Date: 22nd September 2022

Application 3/2022/0827: Application for planning permission for proposed single storey extension to the rear, removal of existing uPVC window and door to the rear of the lower ground floor. Installation of 2 conservation roof lights in rear roof pitch, with internal lightwells to ceiling. New stud walls to form en-suite on the second floor. Removal of existing external soil stack to the rear and installation of new internal soil stack. Removal of existing garage and construction of replacement garage. Resubmission of application 3/2021/0985

Application 3/2022/0828: Application for Listed Building Consent for the above works

84 Whalley Road Clitheroe BB7 1EE

PROPOSED SITE PLAN
SCALE 1:100

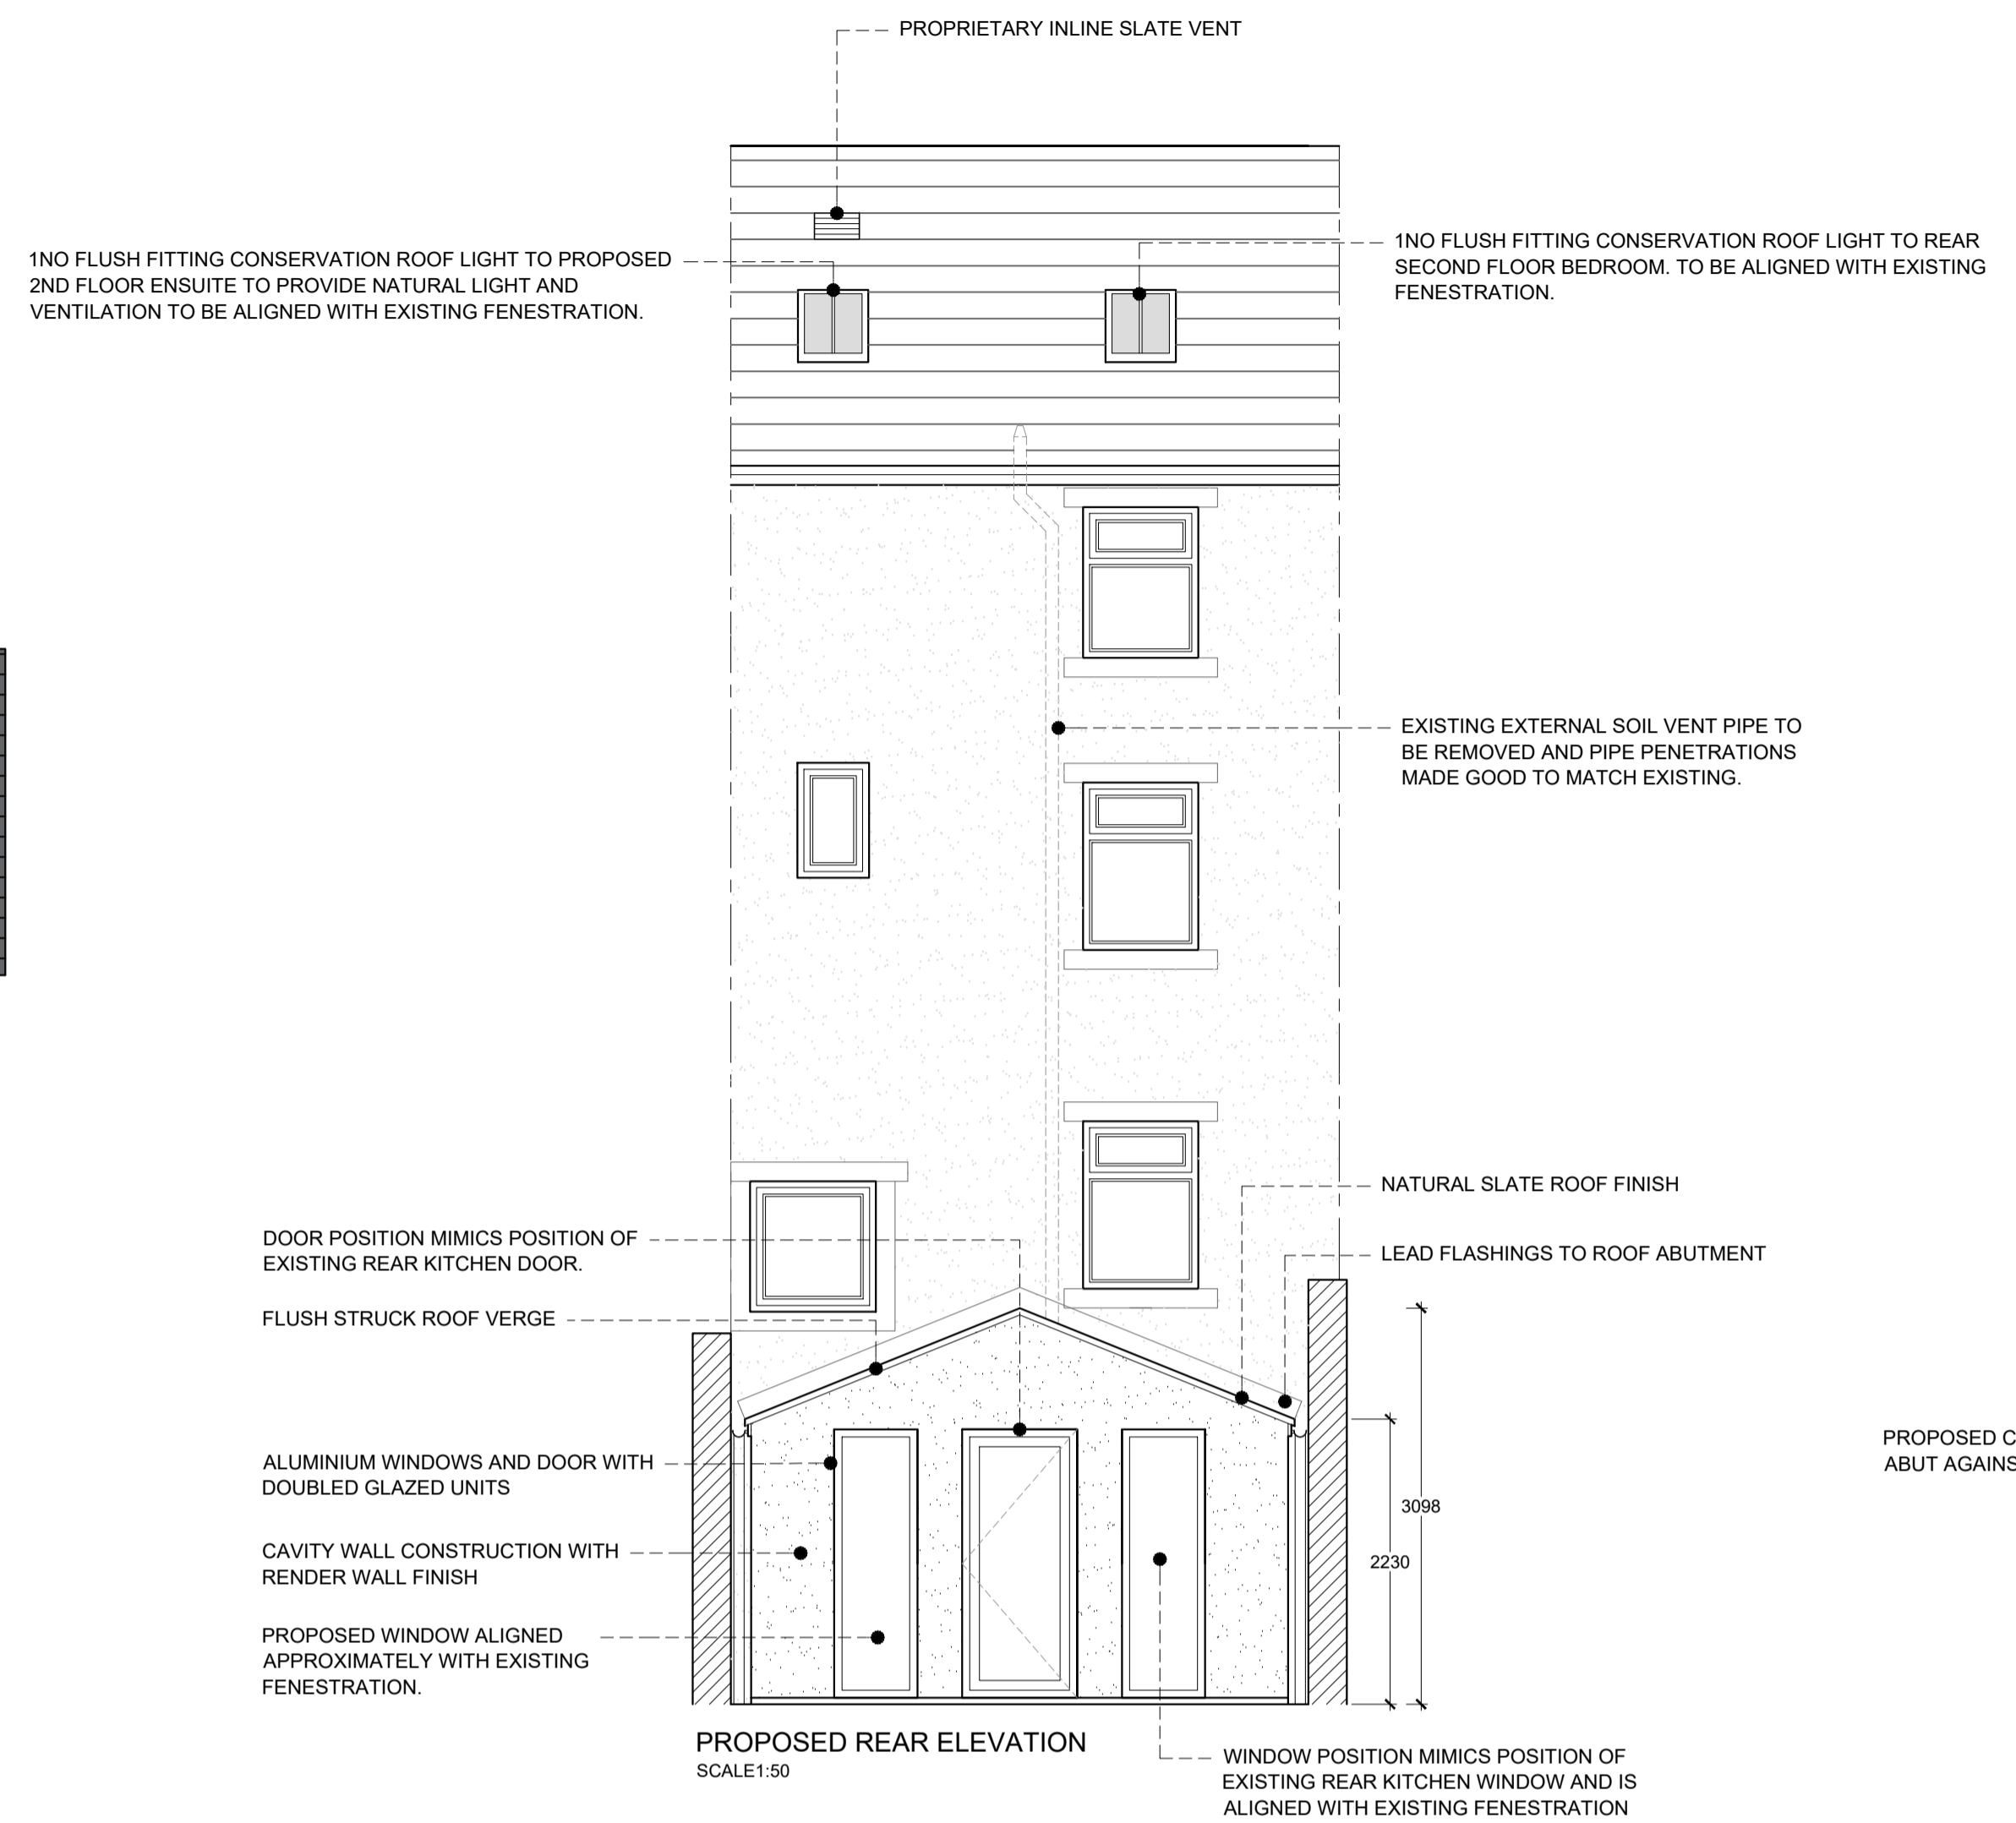
We would support the reasons for refusal of the previous application and be content to leave consideration of the impact of the revised proposals to the Borough's Conservation Officer, but would note that there are few rear extensions to this row existing and that there is public access to the rear of the property via the side/rear car park and access track, as well as the public open space of the former Primrose Mill lodge and race immediately to the northwest. Google Streetview images dated July 2016 would suggest that views of the rear of the property are rather more than 'minimal' as stated on page 7 of the Heritage Impact Assessment (SPA, Sept. 2021). Whilst fences and vegetation do conceal much of the present lower ground floor walls, the proposed extension and its modern gable-end openings may well be more visible.
